May 16, 2022

**Re: Raising Cane's 4800 Montgomery Blvd. NE
Erosion and Sediment Control Plan
Engineer's Stamp Date 5/12/22 (G17E011)**

C3.0

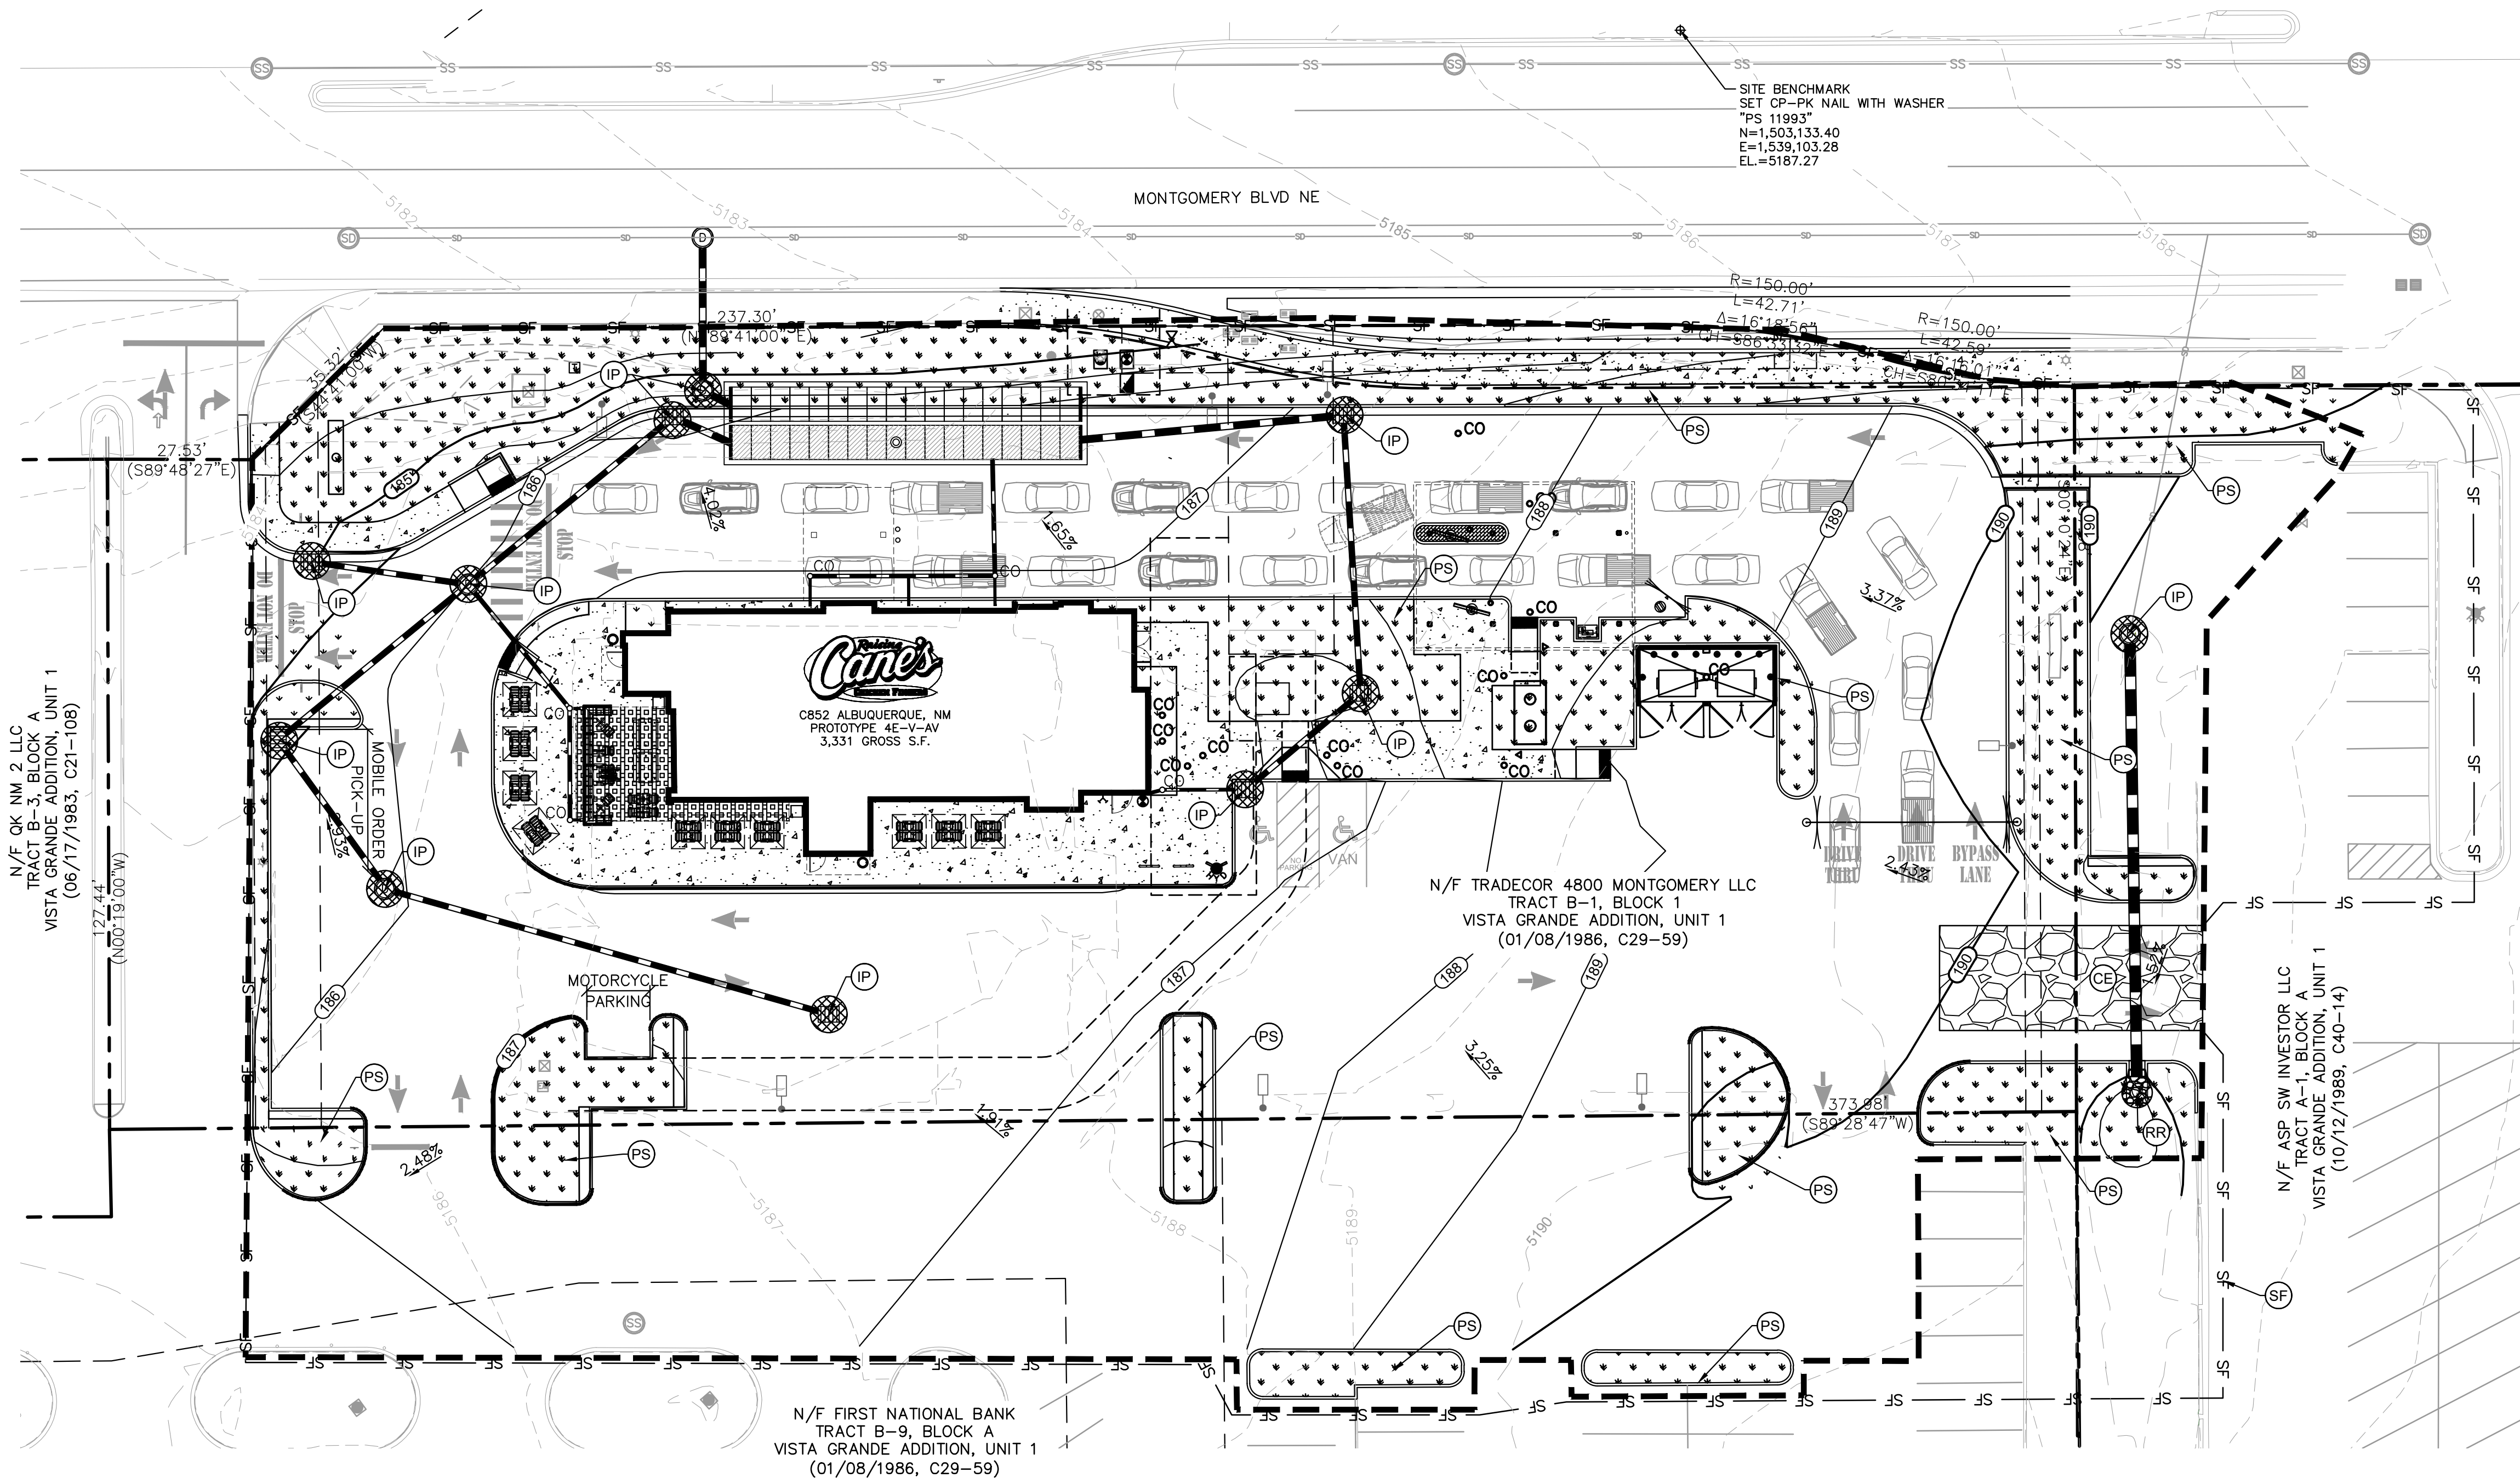
1. The existing and proposed grades and storm drains must be shown on the ESC Plan, and they must agree with the Grading Plan approved by Hydrology (CGP7.2.4.b.ii);
2. The limits of disturbance must include all frontage improvements (CGP7.2.4.b.i);
3. Describe the Work Order construction in the Schedule and Phasing and add BMPs for that phase of the work.
4. Update the engineer's stamp date each time the plan is changed.
